Appeal Decision

Appeal Ref: APP/R4408/W/21/3280715

46 Sheffield Road, Barnsley S70 1HS

- The appeal is made under section 78 of the Town and Country Planning Act 1990 against a refusal to grant planning permission.
 - The appeal is made by Mr Aziz Khan against the decision of Barnsley Metropolitan Borough Council.
 - The application Ref 2021/0454, dated 29 March 2021, was refused by notice dated 20 May 2021.
 - The development proposed is the conversion of first floor flat to HMO and alterations to ground floor offices.
-

PROPOSED FIRST
FLOOR LAYOUT

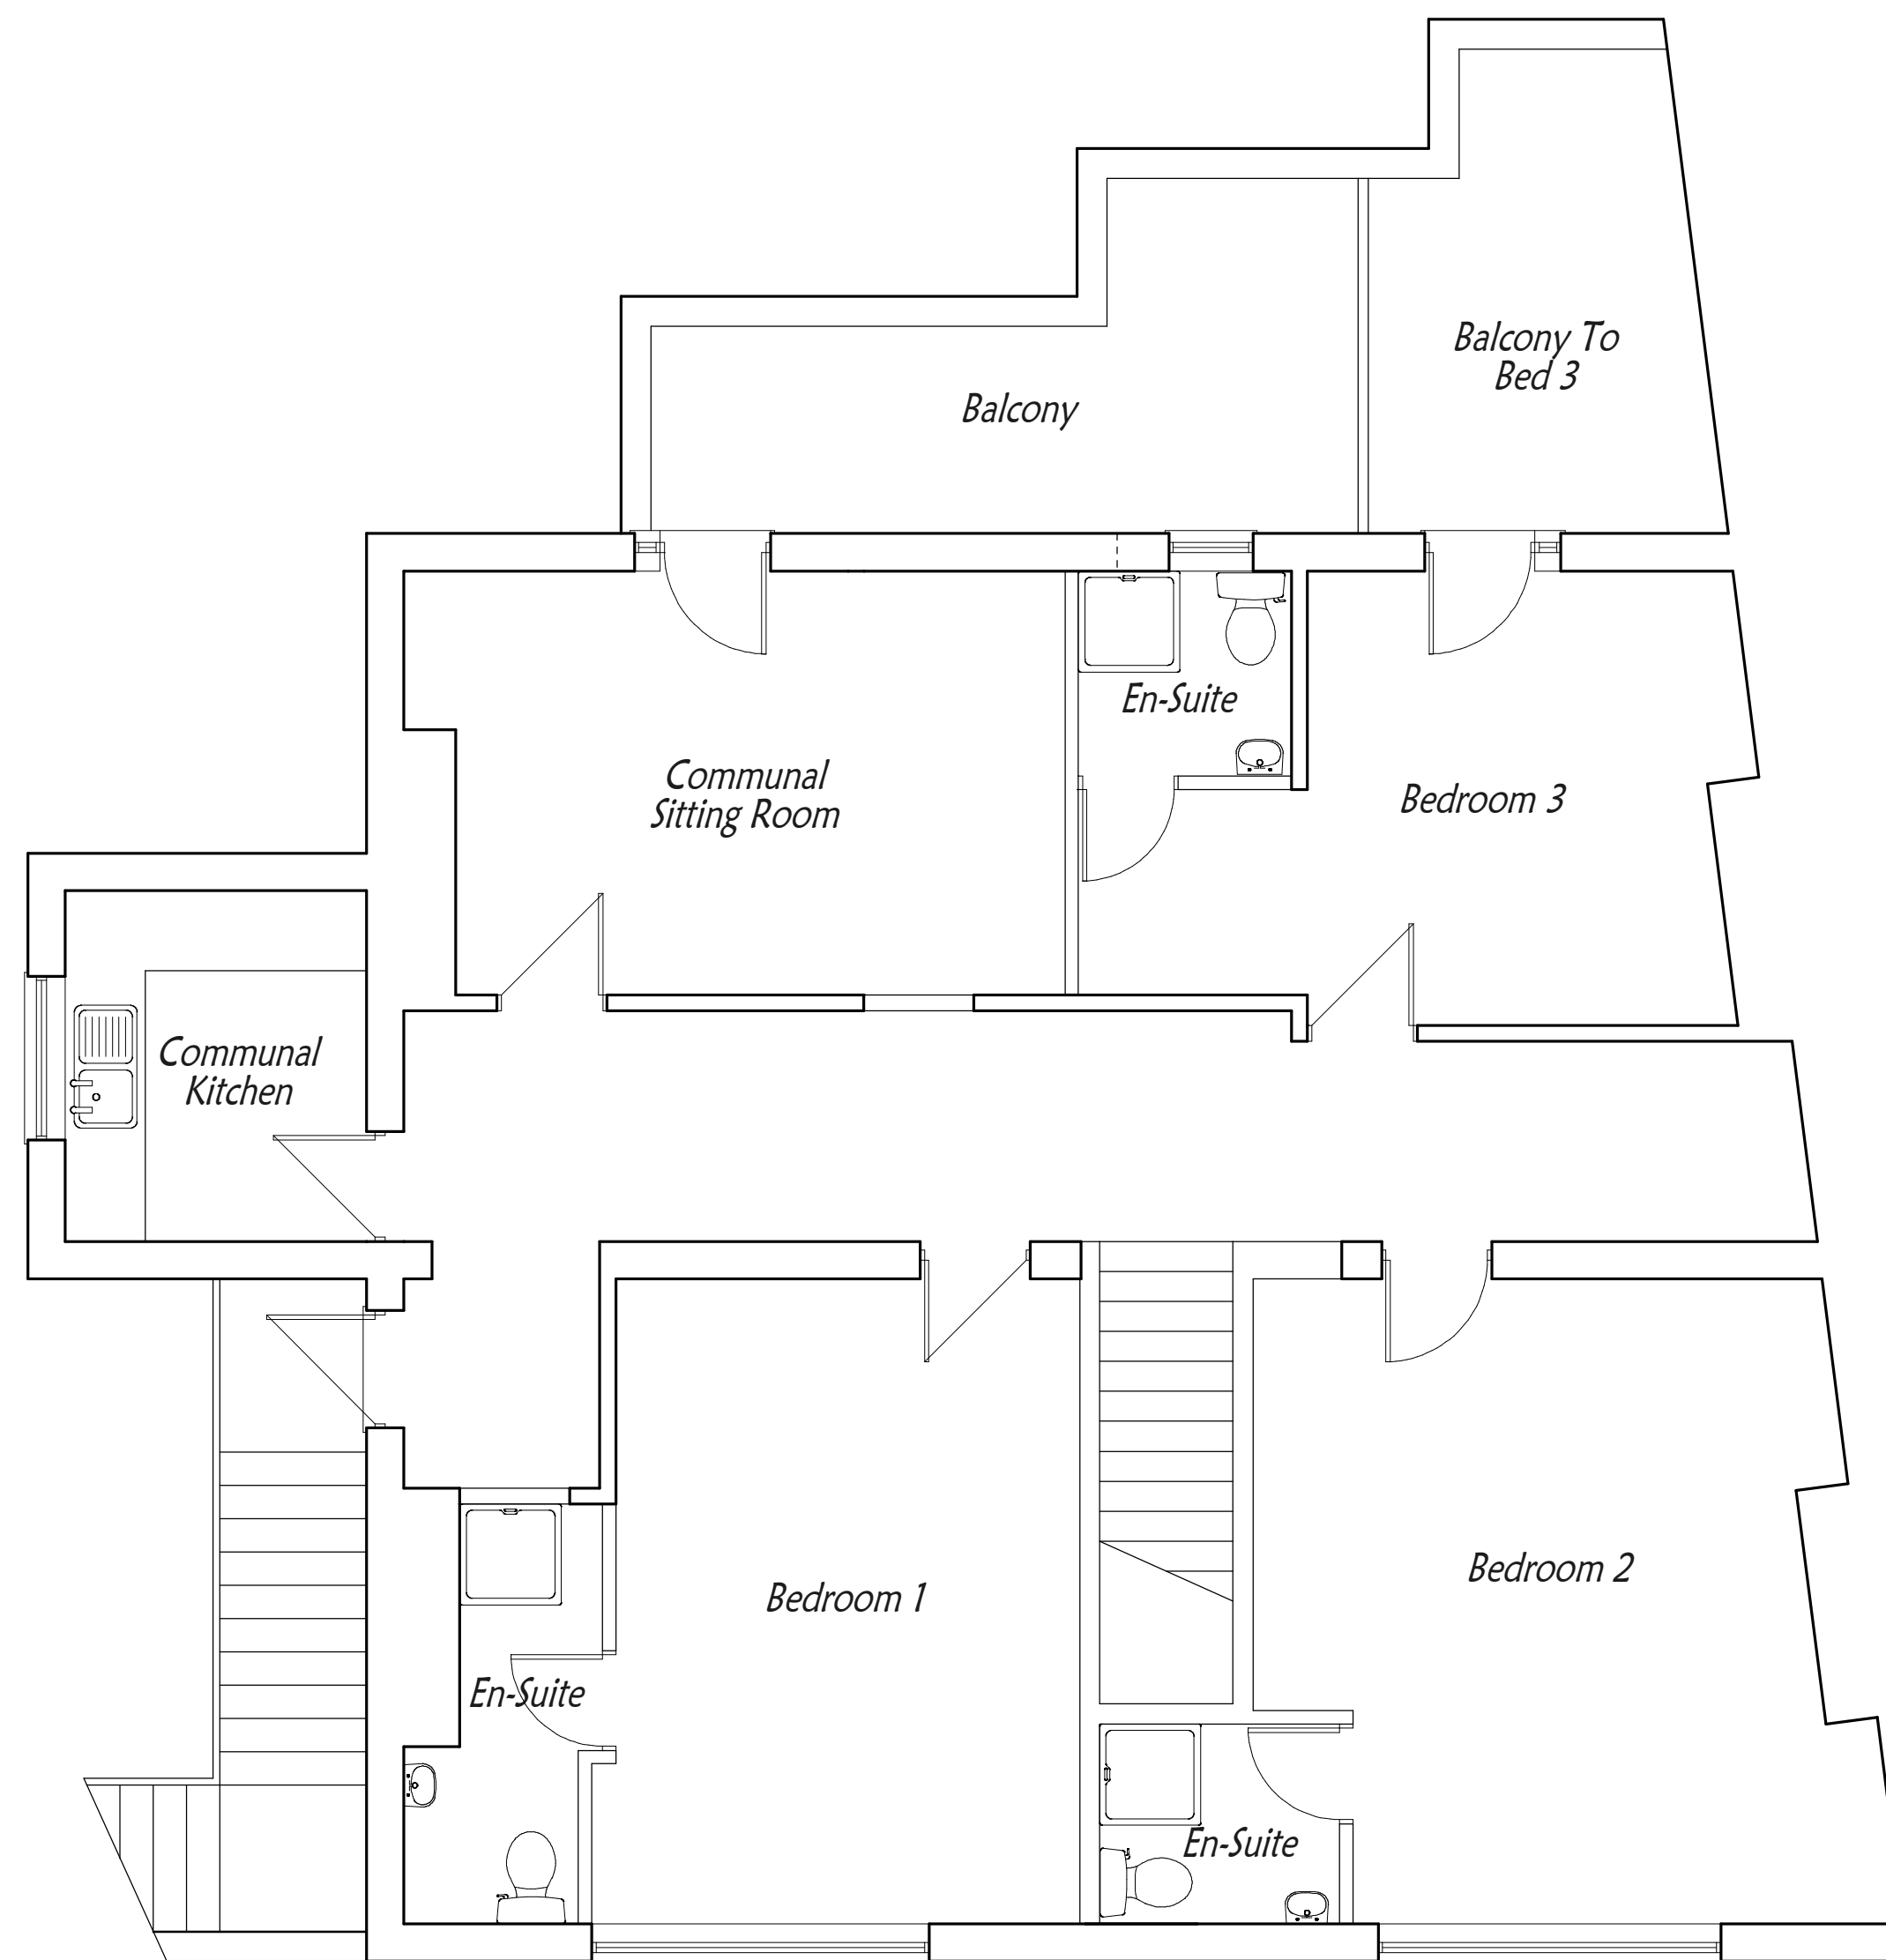
6. The size of the proposed kitchen and en-suite bathrooms would fall short of the internal spacing standards recommended in the South Yorkshire Residential Design Guide (2011) (the RDG). However, I note that the proposed house of multiple occupation does not fall directly into any of the dwelling size categories specified in the RDG.

7. It is also suggested that the external amenity space would fail to comply with the standards set out in the Supplementary Planning Document, Design of Housing Development (May 2019) (the SPD). The proposed shared balcony would, however, provide useable space for future residents and would exceed the recommended standard for a balcony in the SPD. There is also an additional balcony serving bedroom No 3 and a further generous outside area to the rear of the building, which could also provide adequate storage for bicycles.

9. The Council are also concerned that bedroom No 3 and the shared lounge would only be served by a door which would limit outlook and light and restrict the ability to ventilate the rooms. On site I observed that both balcony doors were glazed to the upper sections and had an openable window above them, and a window had been installed adjacent to both doors. As a result, both rooms were light and airy and had a good, open outlook. There is nothing before me to indicate that this arrangement would change.

10. Nevertheless, it is important I consider the proposal based on the information that was submitted to the Council. The doors would be glazed with a fanlight above and sidelight to one side, as indicated on the submitted plans and confirmed in the appellant's evidence. In a similar way to the doors which have been installed, this design would provide future residents with a sufficient outlook, good levels of light and natural ventilation.
